## Appeal Decision

### Appeal Ref: 6001372

#### 35 Moor Park Avenue, Beaumont Park, Huddersfield HD4 7AL

TITLE: FIRST FLOOR EXT'N & SINGLE STOREY REAR EXTENSION  
PROPOSED FLOOR PLANS & ELEVATIONS

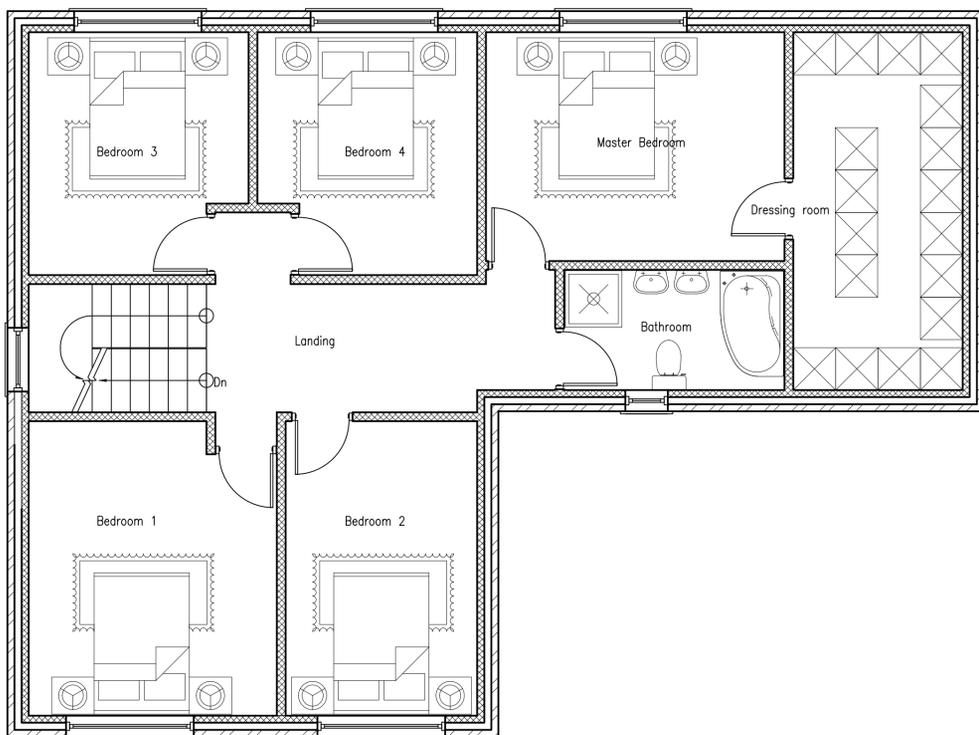
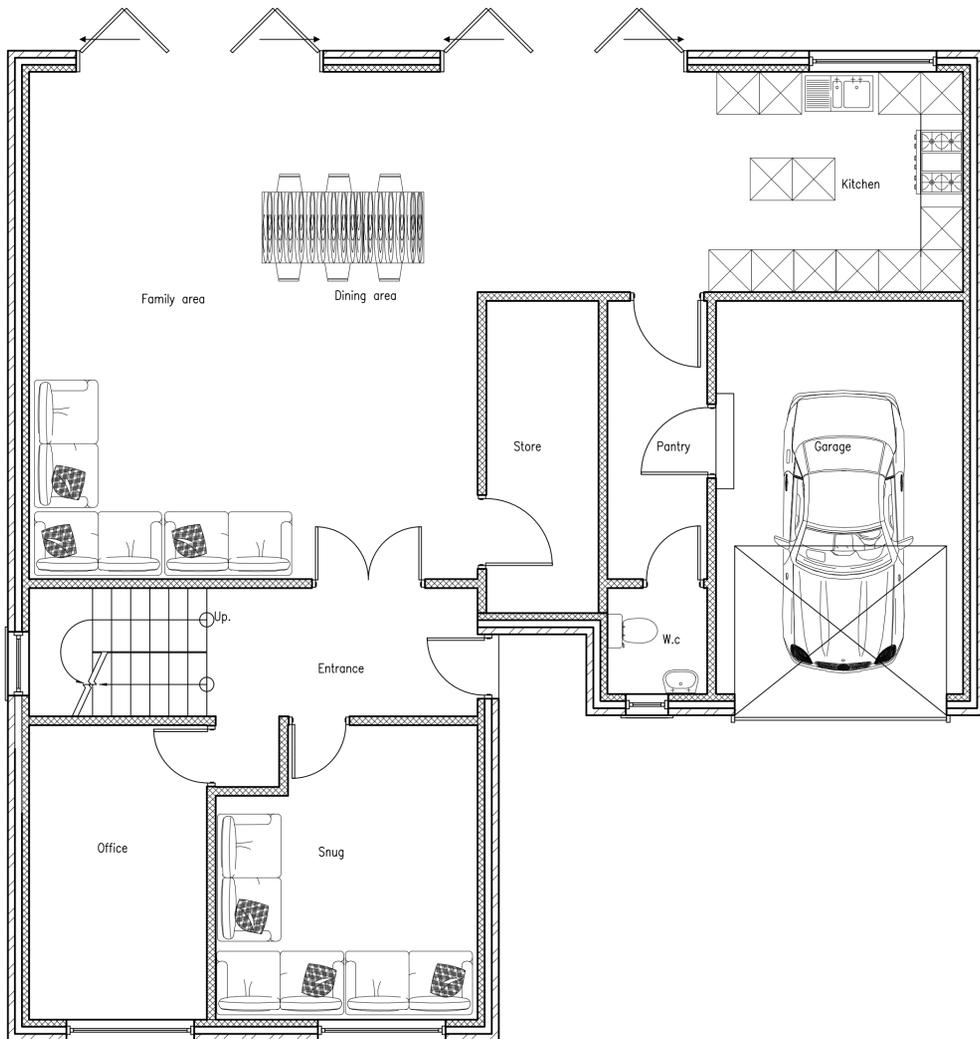
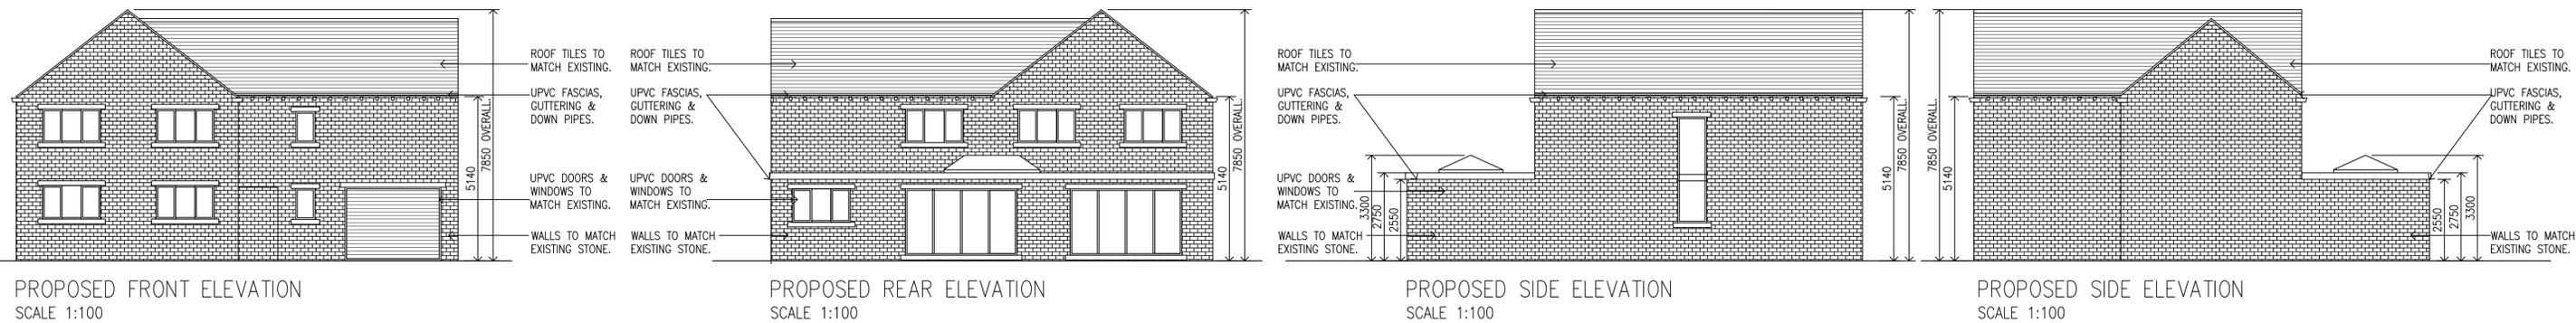
6. The proposed roof profile and materials would match those of the existing dwelling. The additional storey has also been designed so that its fenestration aligns with the existing openings.

7. The proposed additional storey would substantially change the character and appearance of the host dwelling as it would significantly alter the proportions of the building and increase its massing. The dwelling would appear notably taller and bulkier than the surrounding bungalows which the host dwelling is closely associated with and are characteristic of this part of Moor Park Avenue. Whilst the site is not particularly prominent in the streetscene, the proposed additional storey would be conspicuous from the highway. For these reasons, the proposed external appearance would be out of keeping and unduly obtrusive with the host dwelling and this part of Moor Park Avenue due to the proposal's height, scale and massing.

9. For the reasons given above, and considering the highlighted legal judgement<sup>2</sup>, the proposed additional storey would have an unacceptable and harmful effect on the external appearance of the dwellinghouse (AA.2(3)(a)(ii)).
